# **SUBMISSION RELATING TO DEVELOPMENT APPLICATION FOR 241-249 WHEAT ROAD, COCKLE BAY**

1. This constitutes an objection to the development proposed at 241-249 Wheat Road, Cockle Bay. It is made on behalf of the residents of One Darling Harbour, Pyrmont, who directly face this site.

Building Envelope - 3D View 2

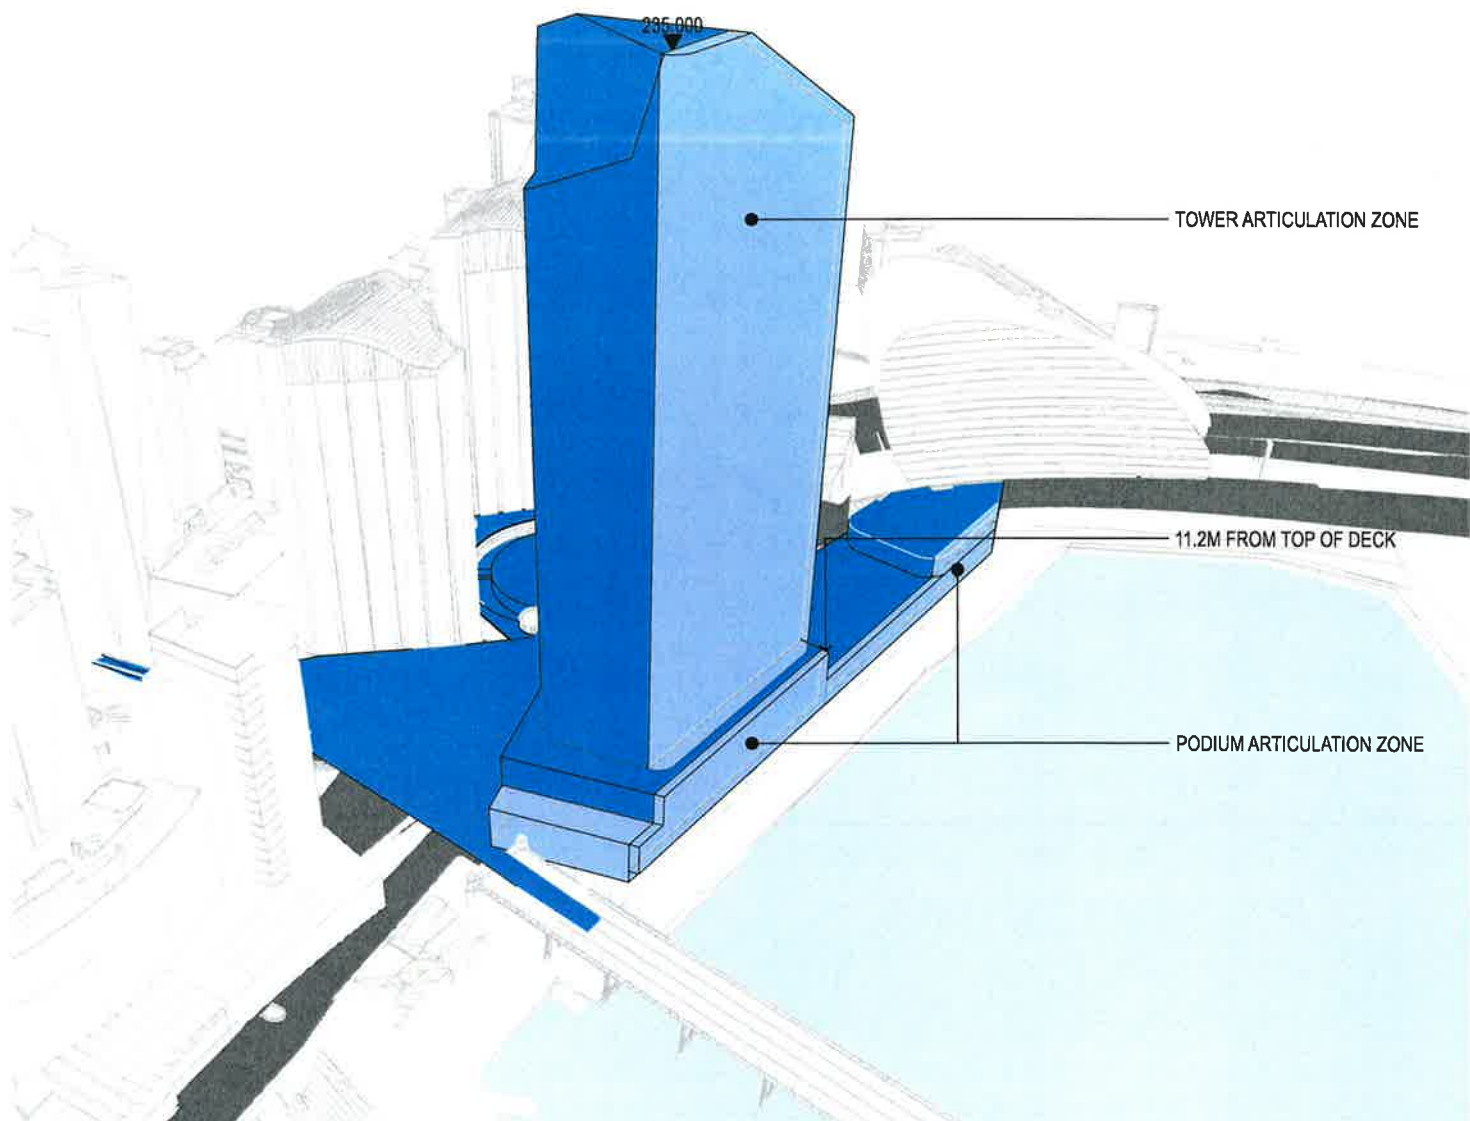
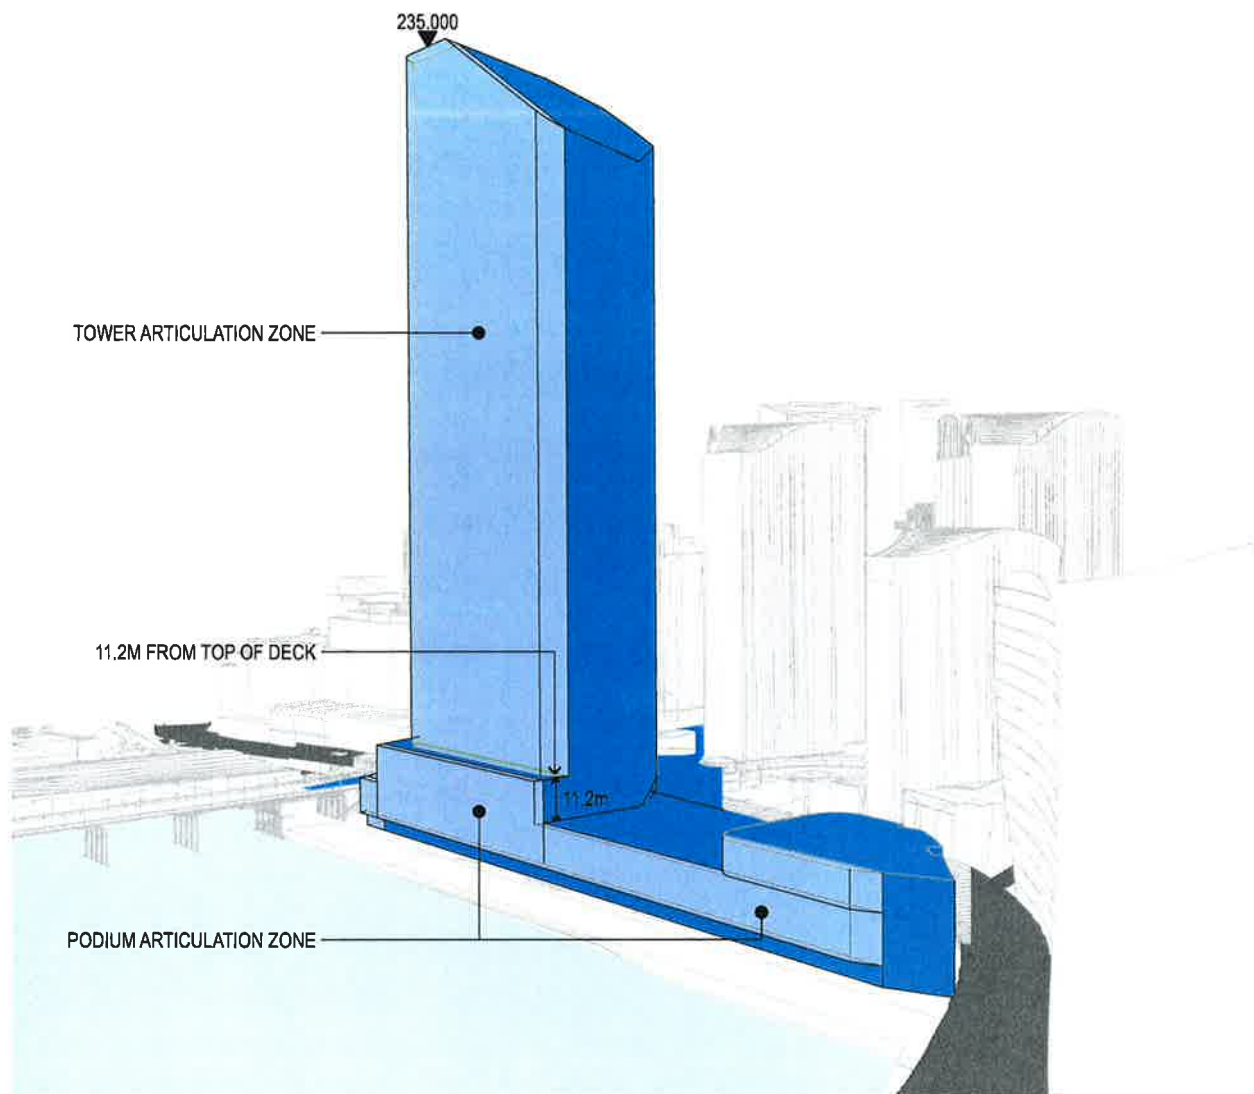
17. The problem which arises is that the proximity of the proposed tower building will dominate Pyrmont Bridge and diminish the heritage significance of the Bridge.

18. The EIS argues that the verticality of the tower will complement the horizontality of the Bridge. But it will stand as a very fat goal post, which must damage the significance of the Bridge. It will be seen as a very large vertical element compared with the more graceful receding horizontal form of the Bridge.

21. Attached as Appendix II are images included in the E.I.S. illustrating the relationship between the tower building and Pyrmont Bridge, together with the relationship with the existing Darling Park buildings and the proximity to the exceptional heritage qualities of Darling Harbour.

19. If a tower is to be built at all, it needs to be set back to at least as far as the western edge of the Western Distributor. Because it is located in the context of Darling Park it needs to be a smaller tower.
